**Your Ref: 2026/0354
Our Ref: B/01738**

30th June 2026

Land west of Cross Street, Worsbrough Dale, Barnsley – (BARNs) Erection of a residential care home consisting of 6 single bedroom self-contained units and a detached 2 bedroom respite bungalow for young adults (Use Class C2) with associated works including formation of accesses; car parking and landscaping

Site Plan 1:200

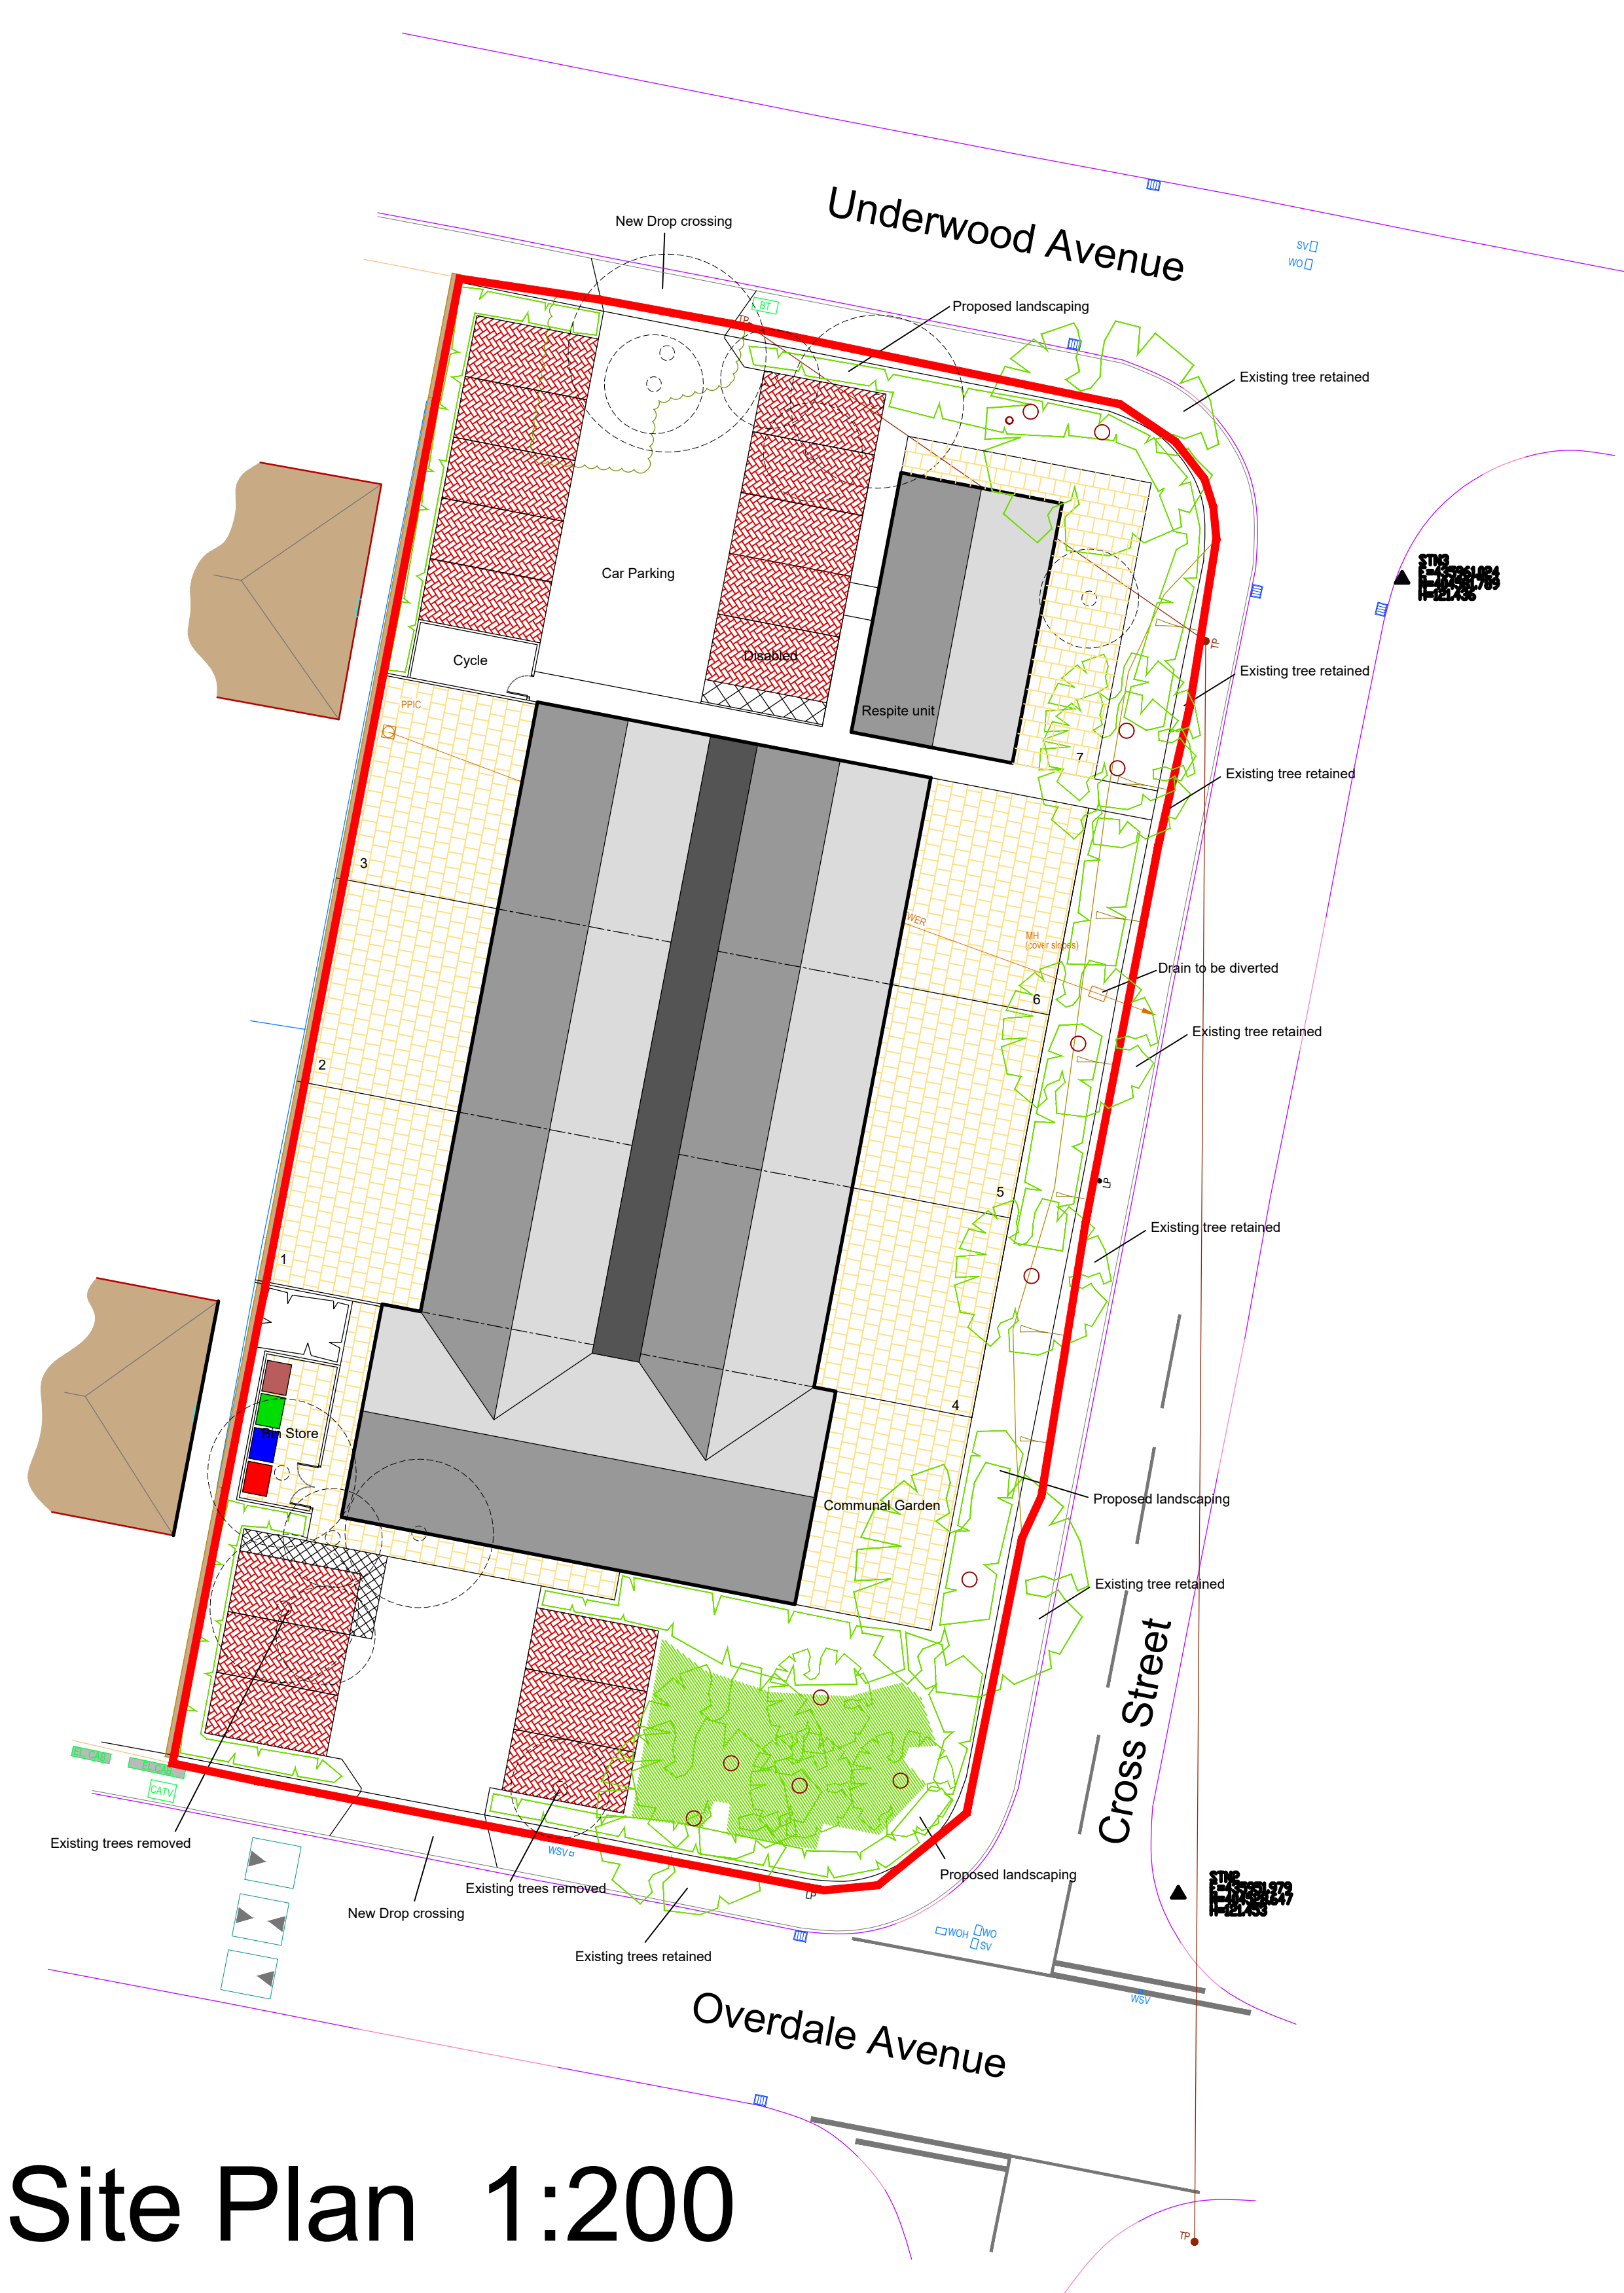
The developer is proposing to discharge surface water to public sewer however, sustainable development requires appropriate surface water disposal.

Yorkshire Water promote the surface water disposal hierarchy and the developer must provide evidence to demonstrate that surface water disposal via infiltration or watercourse are not reasonably practical before considering disposal to public sewer.

As the proposal site is currently undeveloped, no positive surface water is known to have previously discharged to the public sewer network. Surface water discharge to the existing public sewer network must only be as a last resort and the developer is required to eliminate other means of surface water disposal.

As a last resort, and upon receipt of satisfactory evidence to confirm the reasons for rejection of other methods of surface water disposal, curtilage surface water may discharge to public sewer at a restricted rate not to exceed 3.5 litres per second.

On the Statutory Sewer Map, there is an unknown diameter foul water sewer, and a 150mm diameter public combined water sewer recorded to cross the site. It is essential that the presence of this infrastructure is taken into account in the design of the scheme.

It may not be acceptable to raise or lower ground levels over the sewer and we will not accept any inspection chambers on the sewer to be built over.
